Application no: H16/1339/01

Description: Demolition of single storey ancillary buildings,
construct new hall, changing facility, classrooms &
cloakroom

Location: Ayscoughfee Hall School
Welland Hall
London Road
Spalding

**AYSSCOUGFEE HALL SCHOOL, WELLAND HALL, LONDON ROAD,
SPALDING**

CLIENT
Ayscoughfee School.
PROJECT
New School Hall
Ayscoughfee School.
TITLE
Proposed North East &
North West Elevation
Alternative Roofline

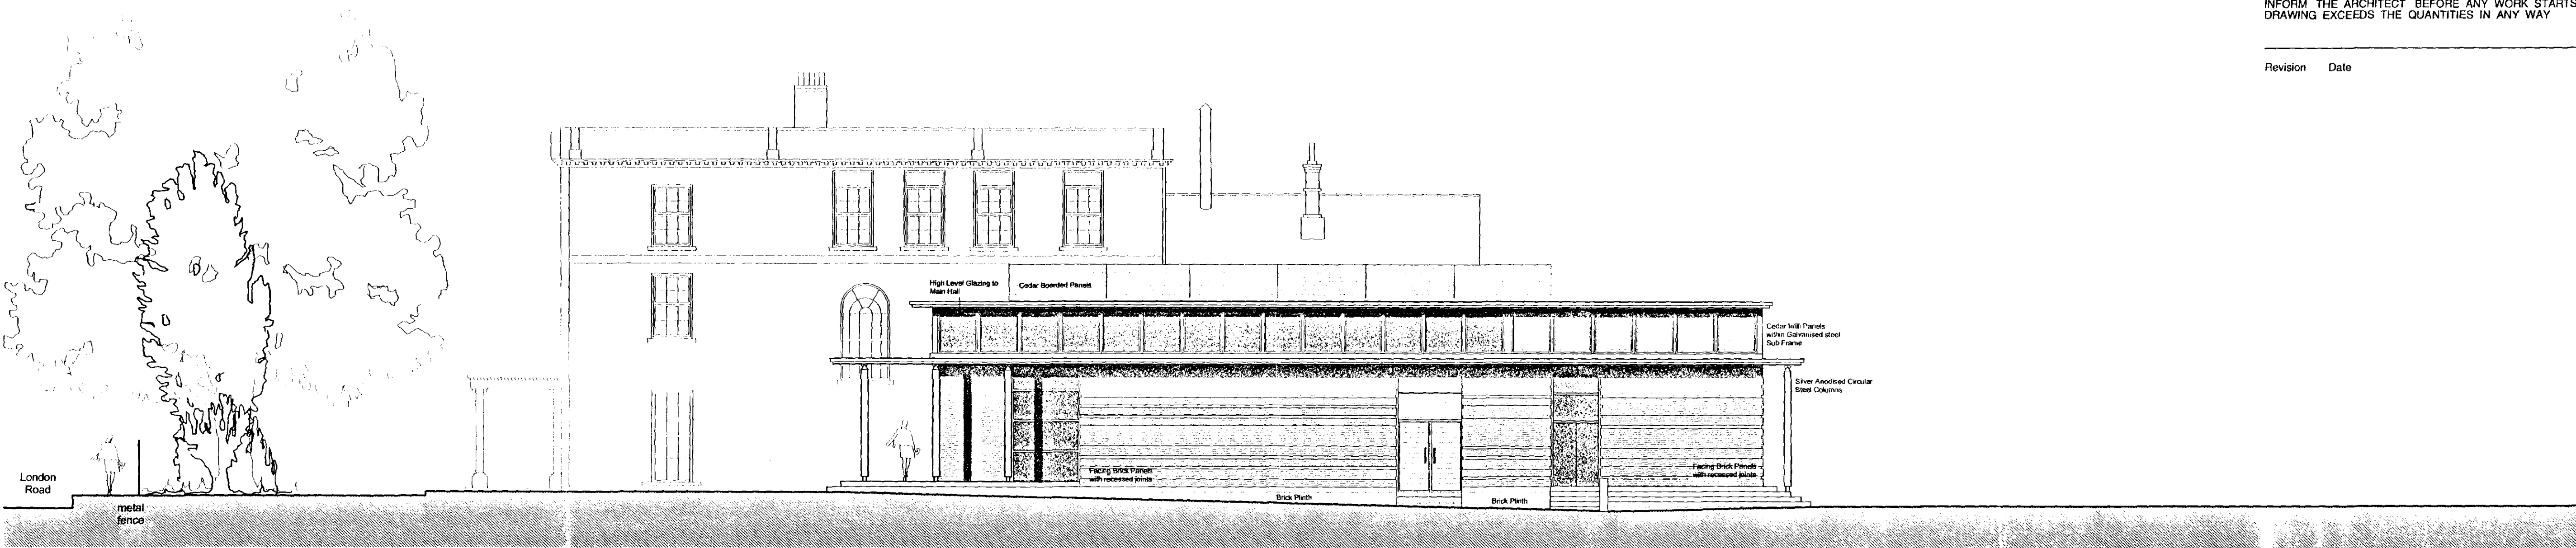
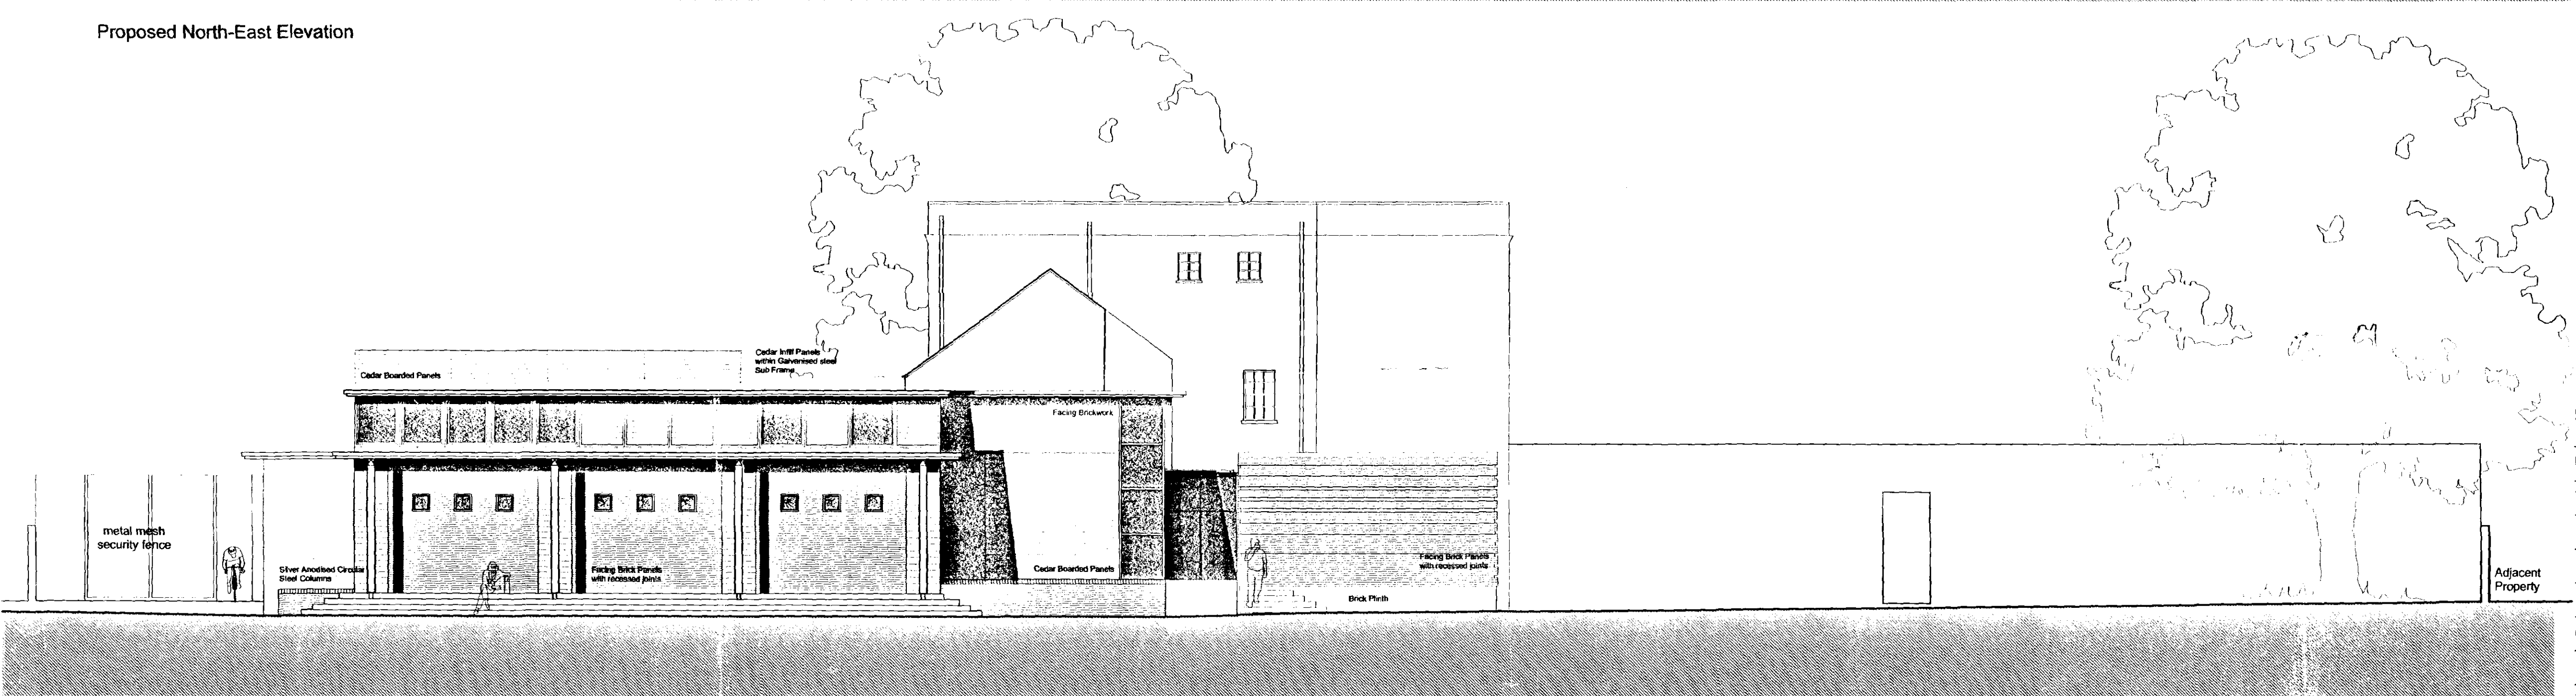
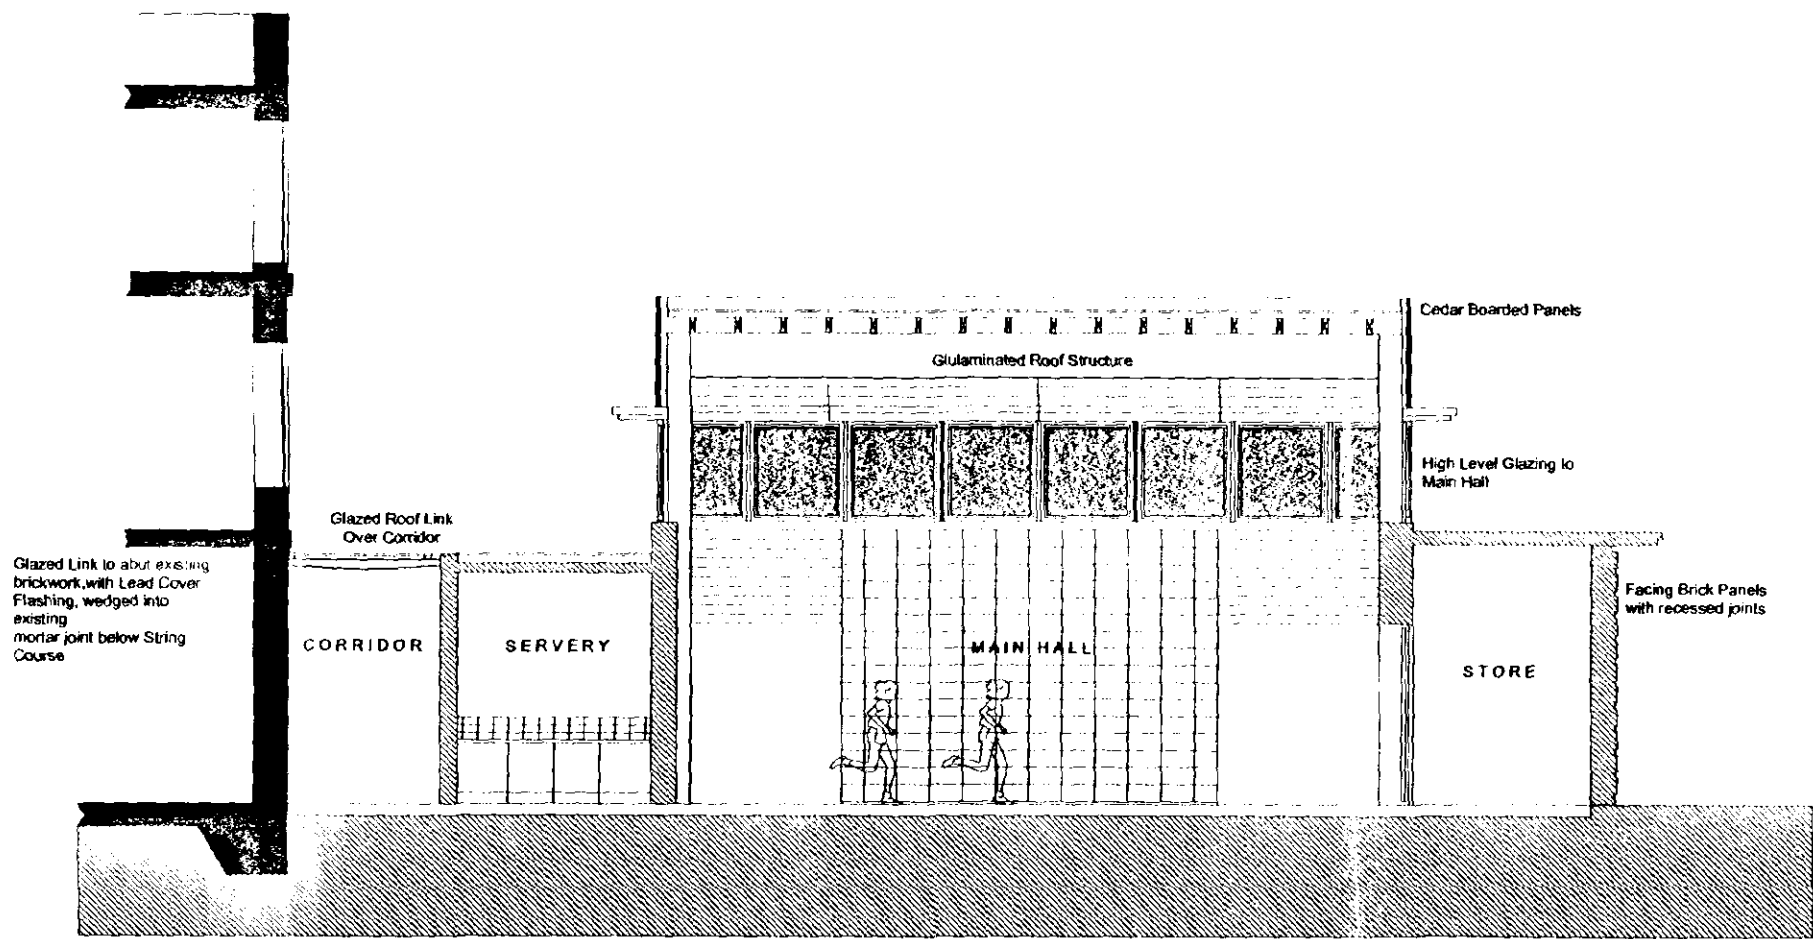
I have also received further amended plans (Drawing Nos 18 and 19) direct from Clews Architects which offer additional improvements.

Turning to the plans submitted, at our meeting it was suggested that the building could be set 3m further back on the site (but maintaining the proposed glazed reception line) and that the upper section of the hall could also be recessed, helping to reduce further the impact of the extension. An additional amendment, reducing the height of the top section to the second floor string course has also been suggested. These changes are reflected (together with other corrections) in the latest plans supplied direct to me by the architects (Drawing Nos 18 & 19). The cumulative effect of these will improve the relationship between Welland Hall and the

new build significantly and more than the 2-D elevation drawings imply. The design of the rear has also been improved and the new building works more effectively in the round – rather than simply as an elevation to London Road.
